**Consultation Response from KC,
Highways Development Management**

2025/90196 Ings Road Fisheries, Ings Road, Batley, WF17 8LT

Erection of single storey extension

PLAN VIEW PROPOSED

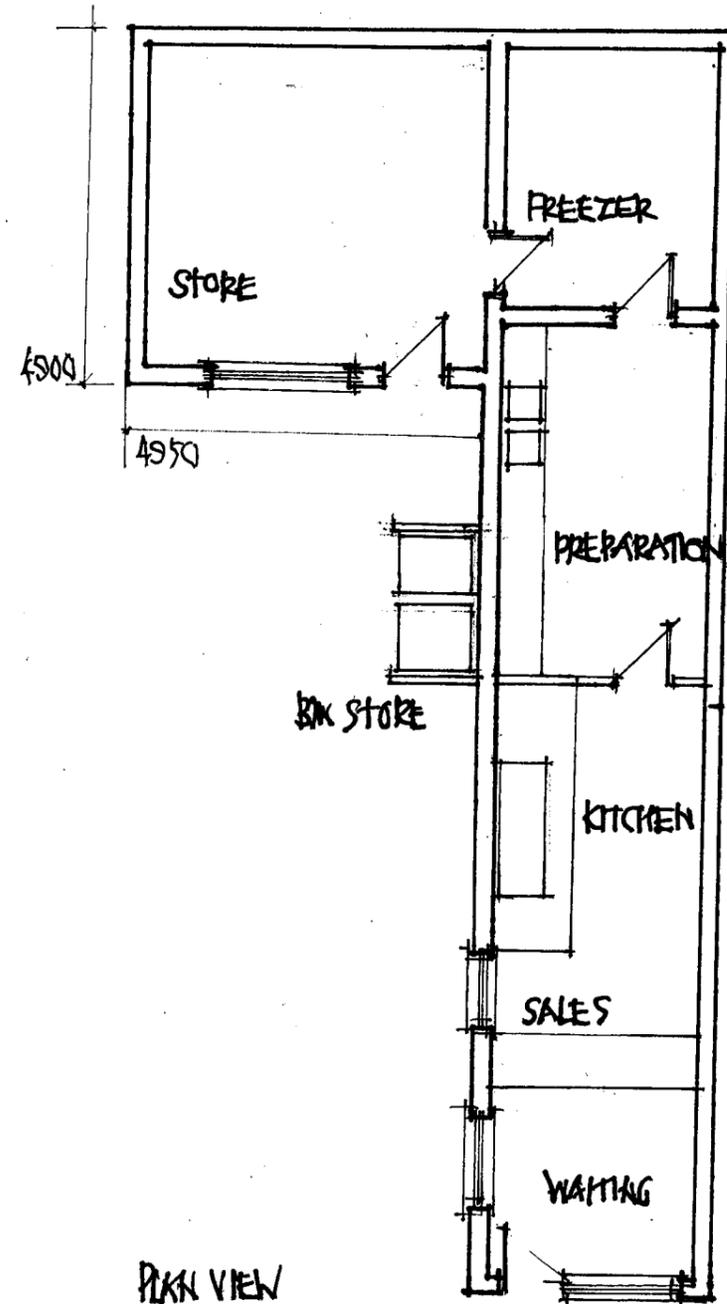
The proposal is to provide a 24 sqm extension to the existing hot food takeaway use. The floor plans show the extension used for storage.

Whilst there are concerns regarding the lack of off-street parking provision at this site and that on-street parking may be at premium along Ealand Road, given the scale of the proposals and that the plans show the extension used for storage Highways Development Management would find it difficult to justify a refusal and on balance have therefore no objection these proposals.
